Our ref: Trinity Grammar School Redevelopment – Modification 2 (SSD-10371-Mod-2)

8 April 2022

Subject: Request for Additional Information

PLANTING SCHEDULE

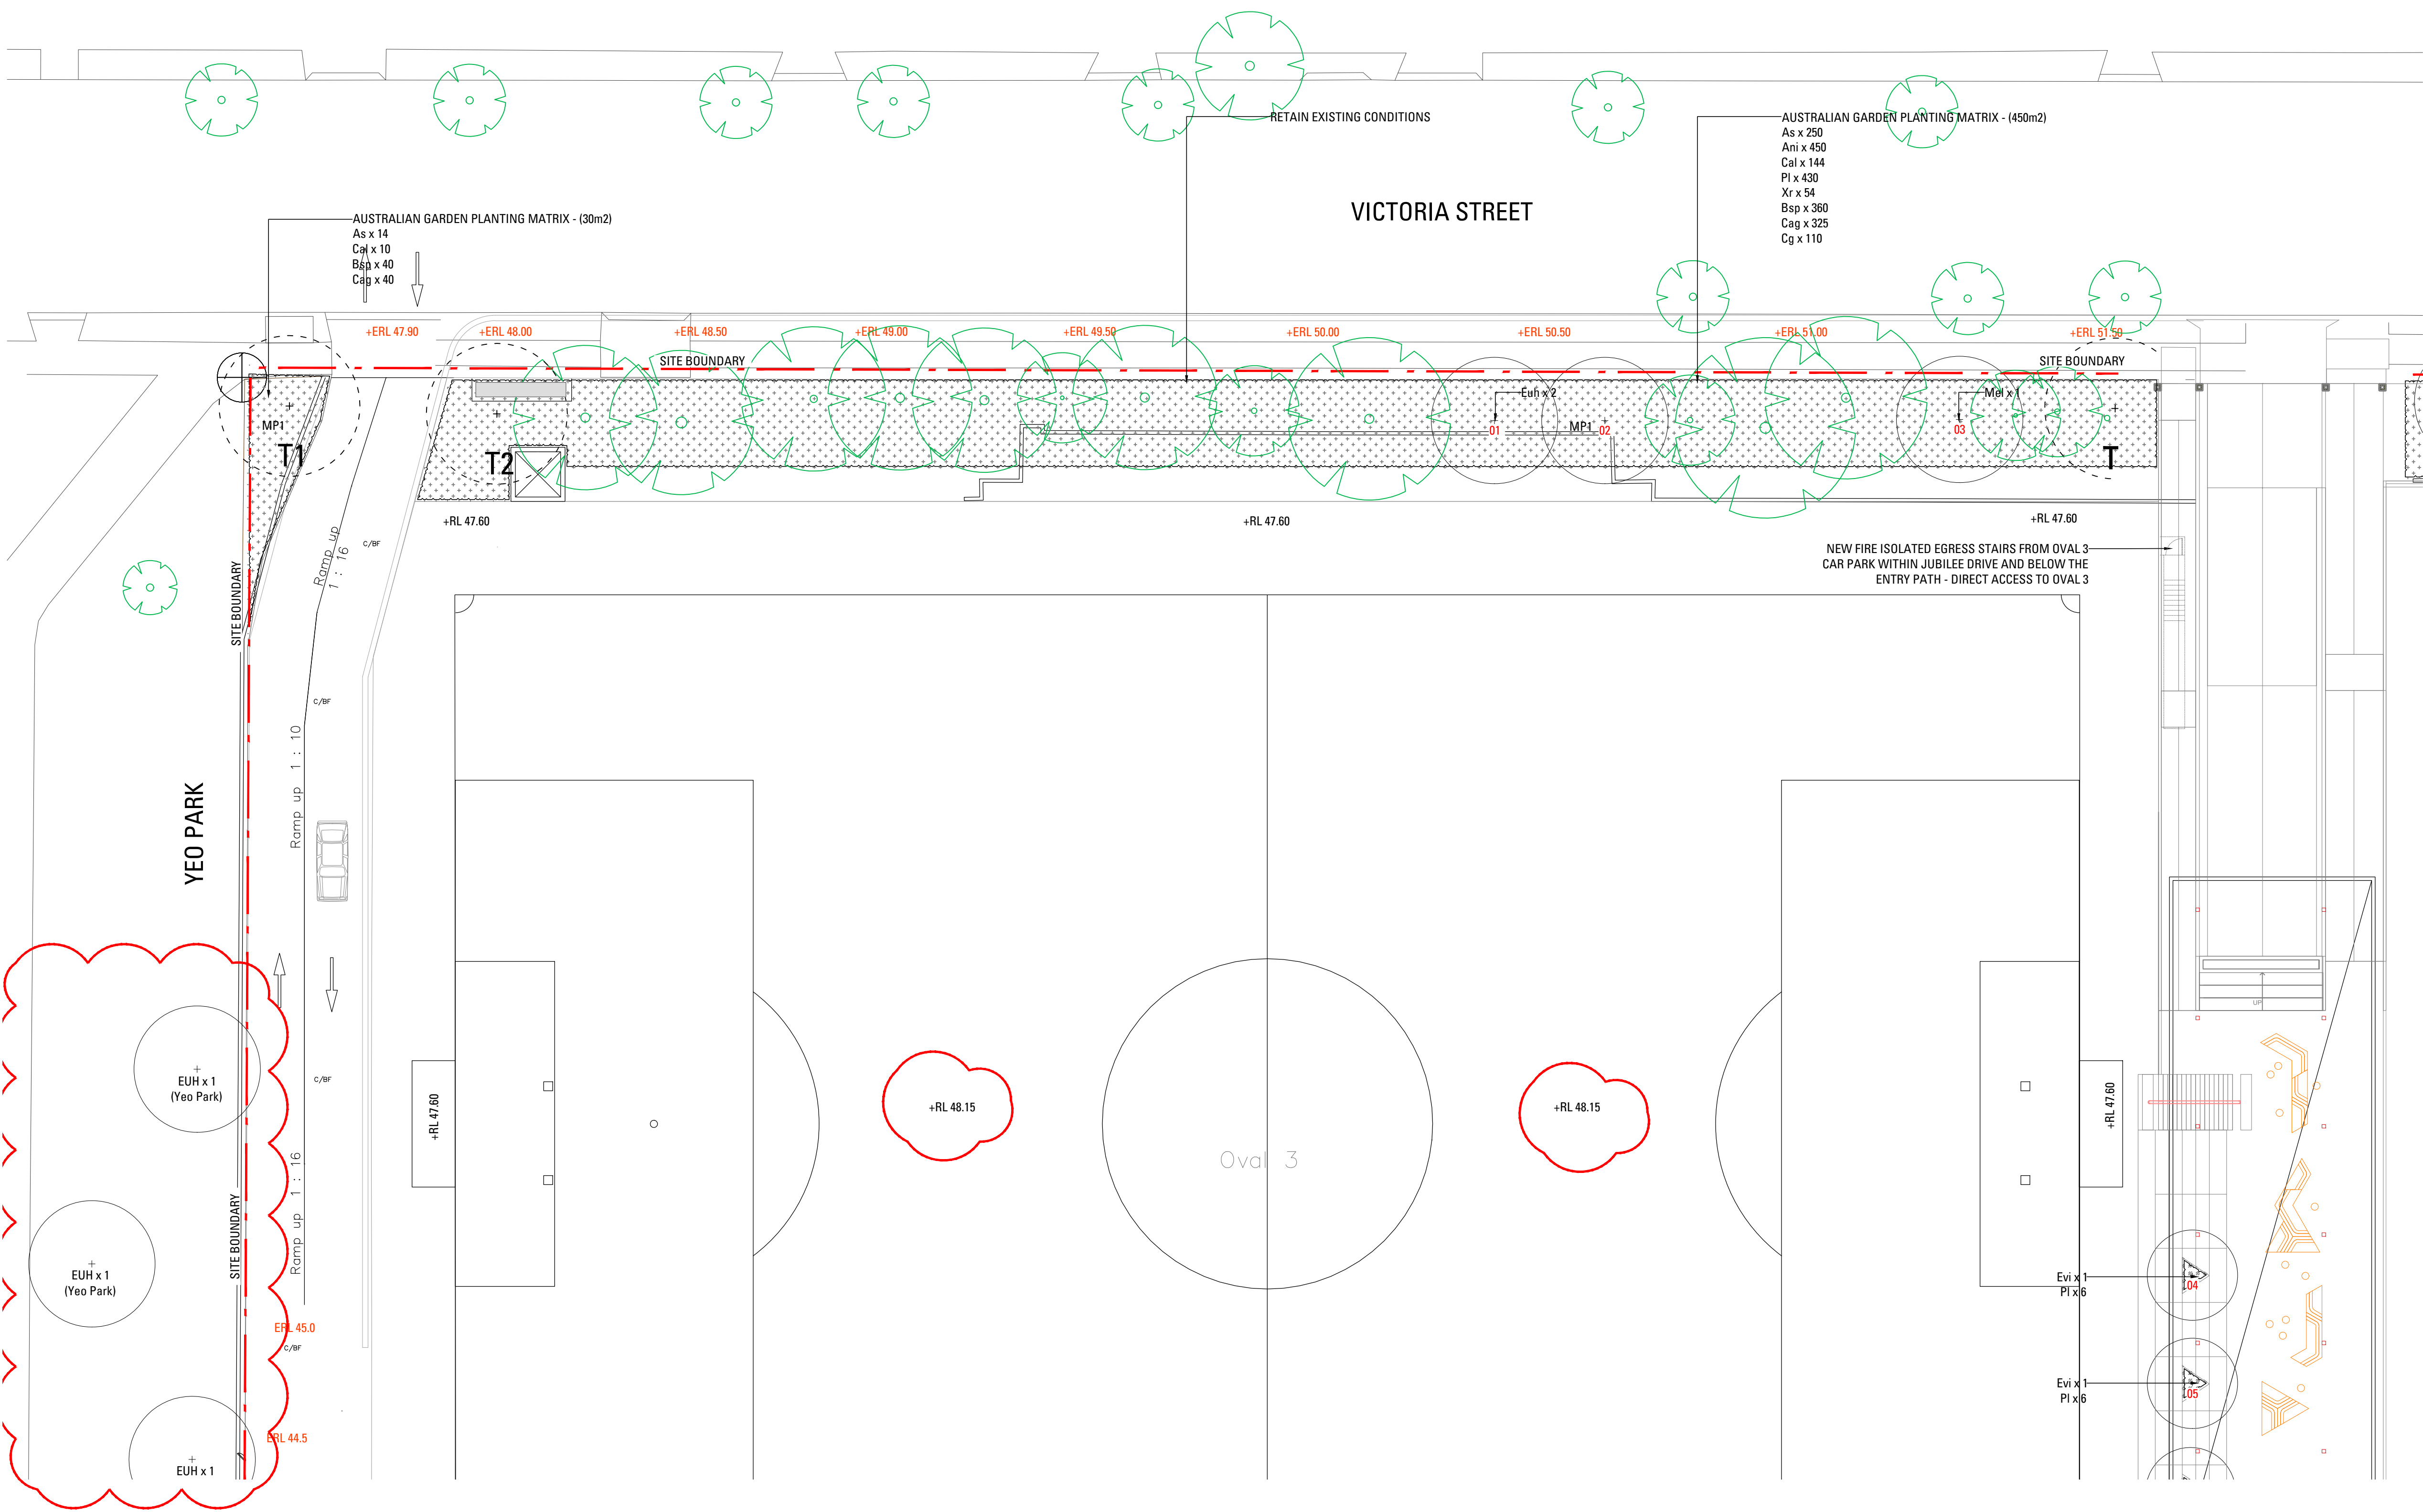
- (b) The Landscape Master Plan (sheet 100) does not accurately detail the location of trees at Lot 7020 DP 93165, when compared to the Landscape Plan Sheet 200.

- (d) All proposed trees on the landscape plans should be number identified. The proposed planting schedule table (sheet 100) should include the tree identification numbers.
